Arun District Council
Arun Civic Centre
Maltravers Road
Littlehampton
West Sussex BN17 5LF
Planning & Building Control General Enquiries
Tel: (01903) 737756 Fax: (01903) 730442
Dx: 57406 Littlehampton
Minicom: 01903 732765
e-mail: planning@arun.gov.uk
website: www.arun.gov.uk/planning

Application No: LU/247/20/PL
Site Address: 57 River Road Littlehampton BN17 5DD
Description of works: Partial demolition of existing building, retention of boundary wall & street facade, partial demolition of boundary wall to incorporate new pedestrian gateway & gate, erection of 6 No. flats in 2 blocks connected by shared stair & lift core, on site parking yard for 8 No. cars & 8 No. cycles & space for communal refuse & recycling bins. This application affects the character & appearance of the Littlehampton River Road Conservation Area & is in CIL Zone 4 (Zero Rated) as flats.

Thank you for your internet representation made on 4th October 2020 which has been recorded as an objection with the comments as follows:

TITLE: PROPOSED GROUND FLOOR PLAN

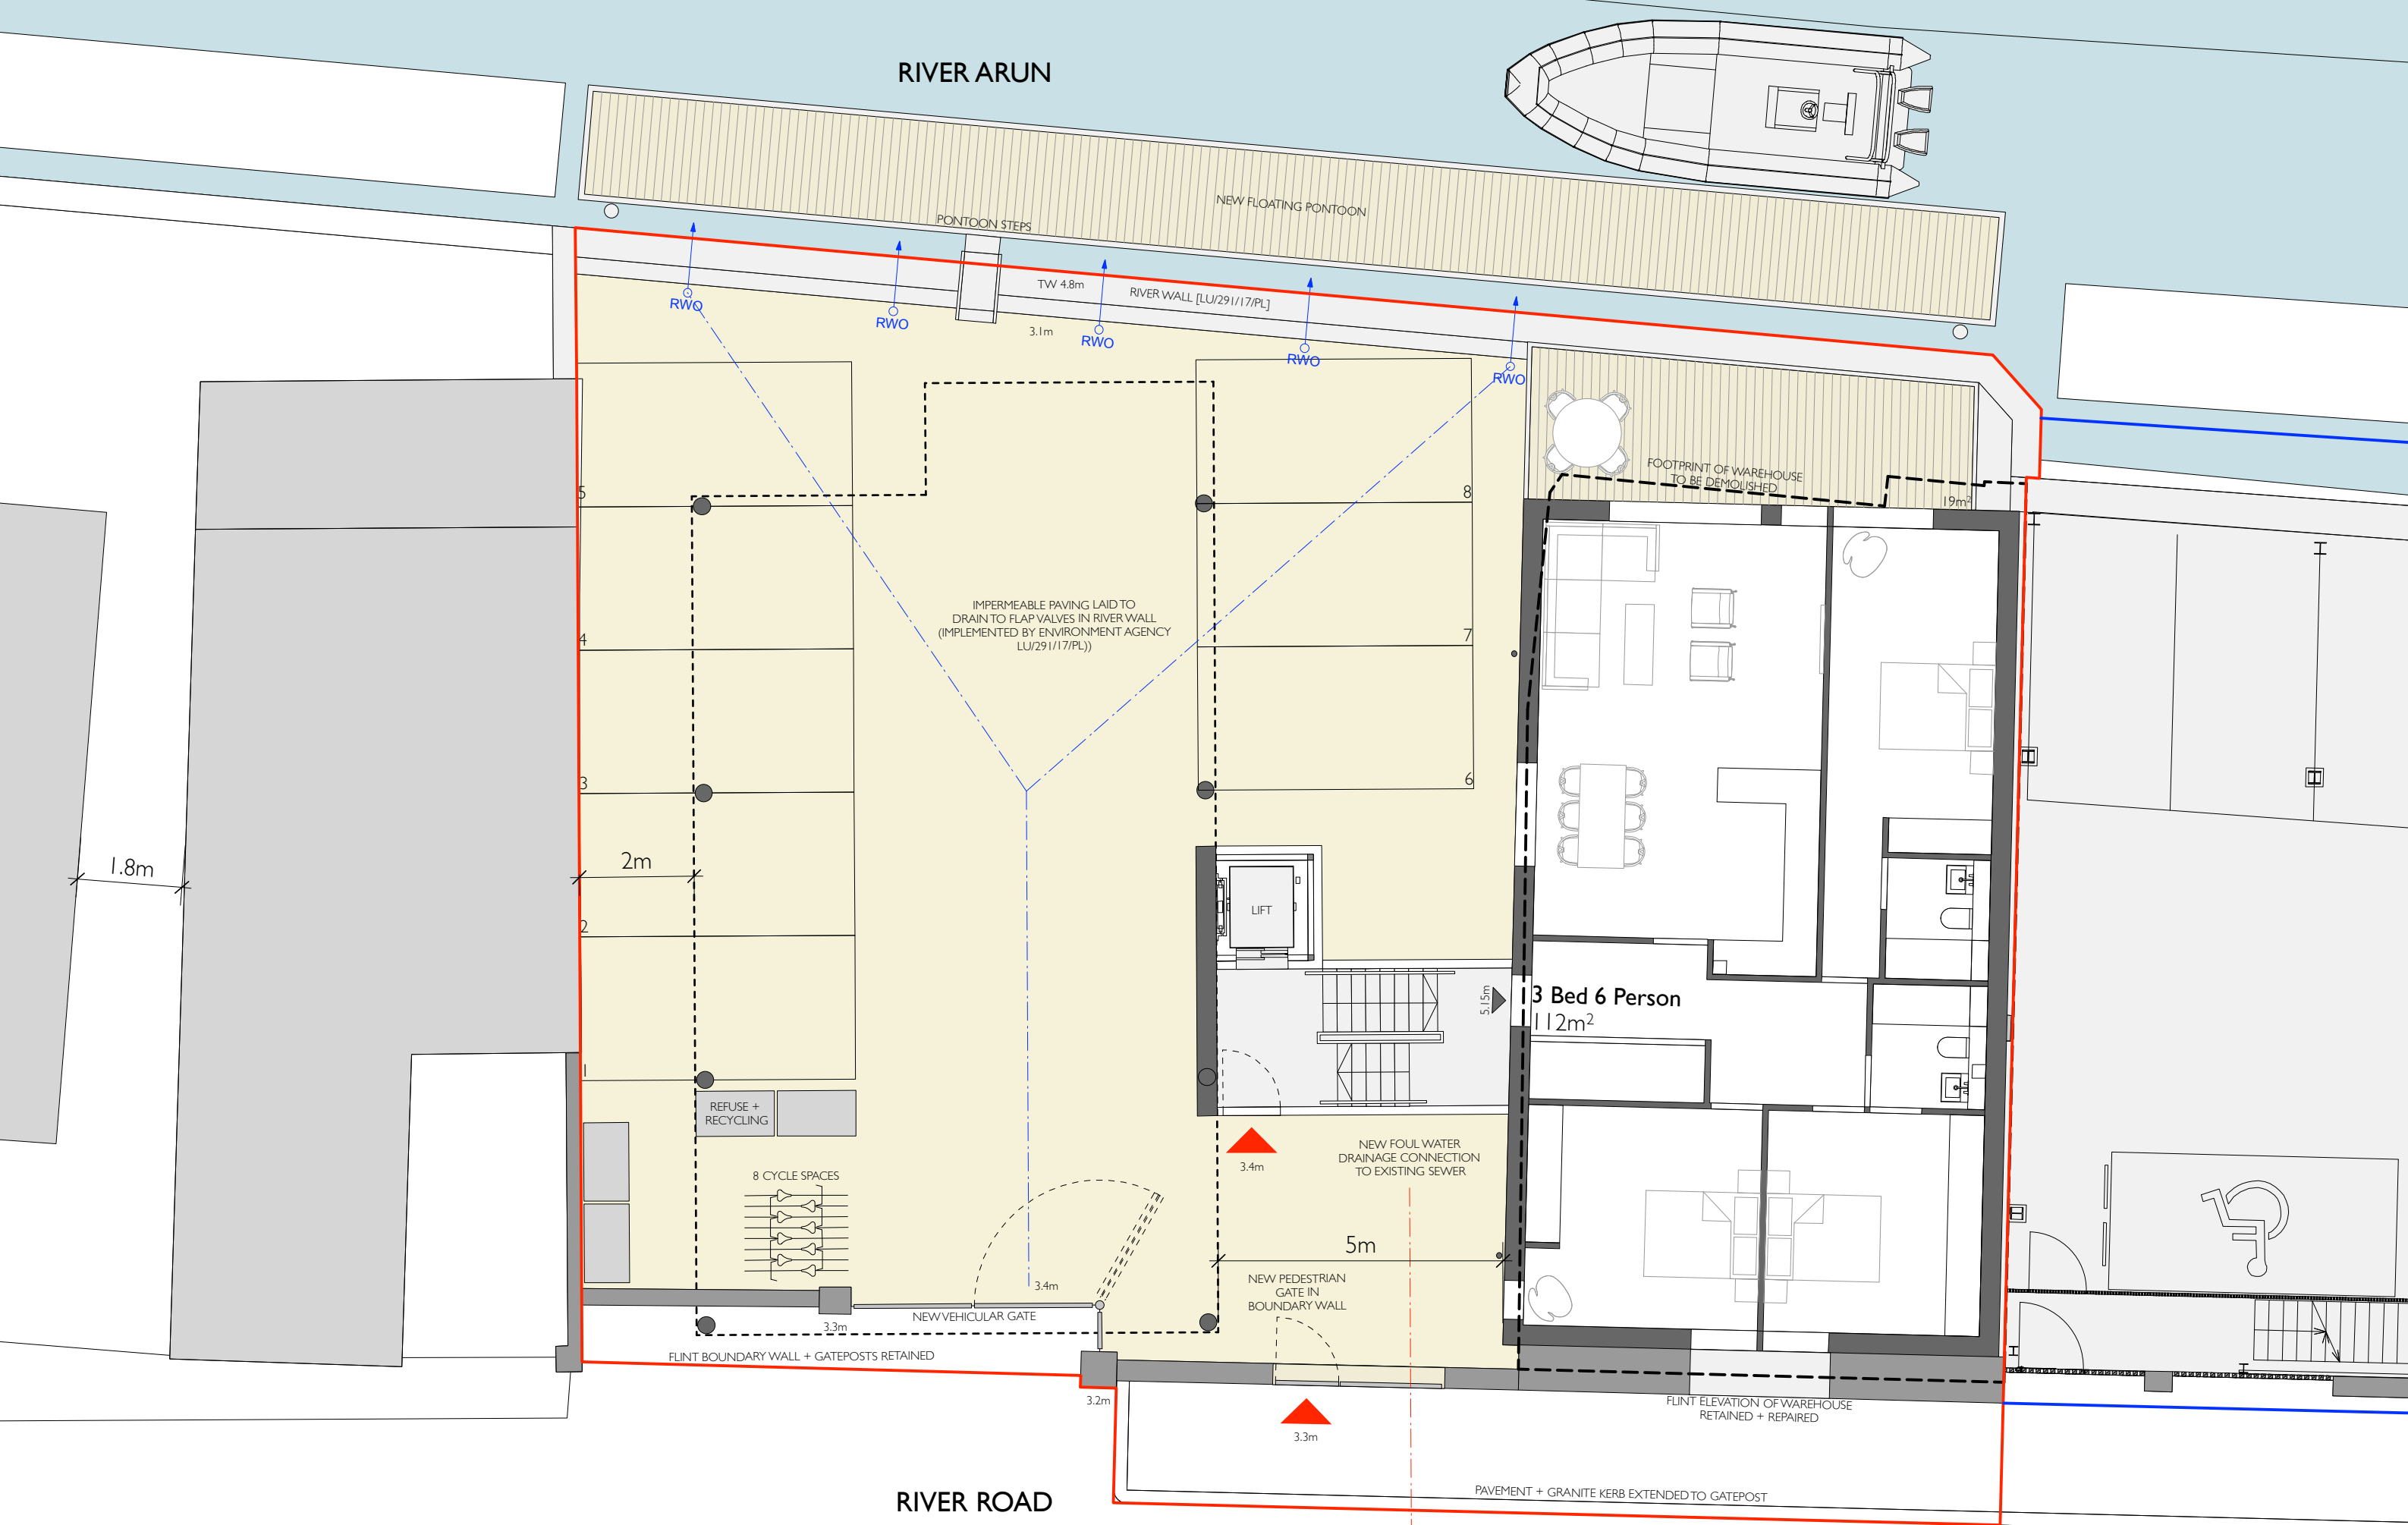
Some drawings show river access from a ladder some distance away from the riverside patio and 1st floor balcony of 49.
Others show a ramp starting at the boundary of 49.

This would significantly affect the residents privacy, not to mention the impact of a huge metal stairway and landing to access the ramp over the flood wall.

The car parking space shown does not abut the patio space of 49, however unless a barrier is put in place, this area would inevitably be used for vehicles, affecting the privacy of 49.

Also I would suggest a barrier along the north boundary wall of 49 to stop cars hitting and damaging the structures.

TITLE: PROPOSED SOUTH EAST ELEVATION

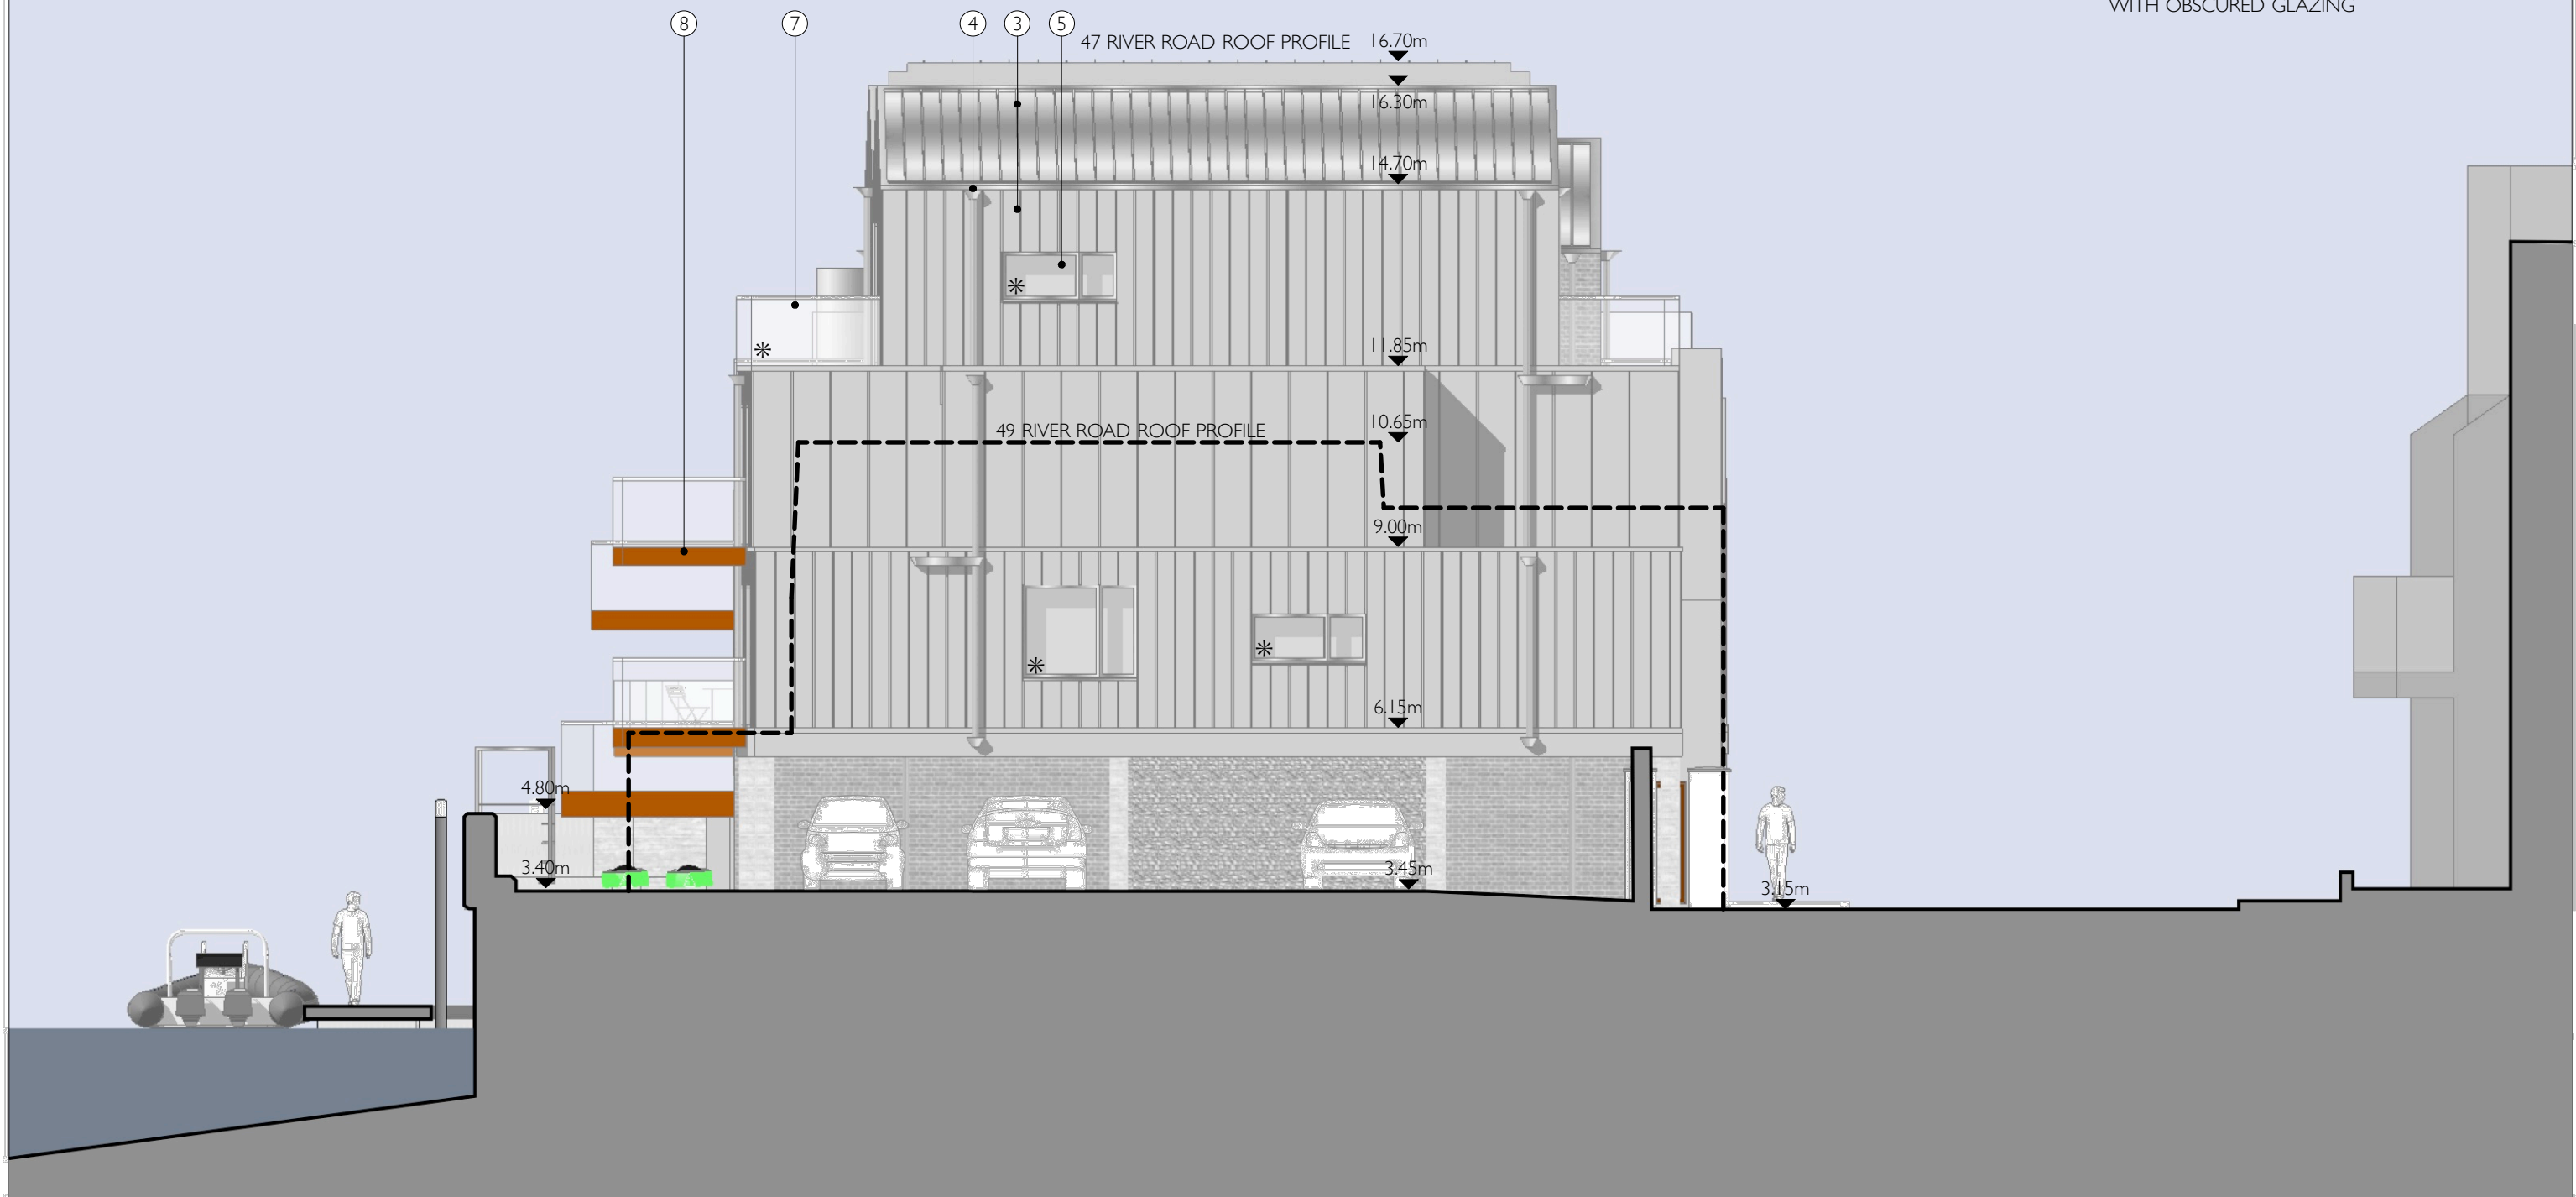
There is no south eastern elevation plan.
This makes it difficult to determine materials, and more importantly, the windows and doors.
There are flat roofed set backs in the construction
The drawing states that there is no access to the second floor ones to protect the privacy of 49, however the third floor is a terrace with access.
This will look directly through the roof window of 49, and with a small amendment to the plans connect to the river balcony.
These building have enough balconies overlooking my outside space. I don't think it is necessary to invade my internal accommodation as well.
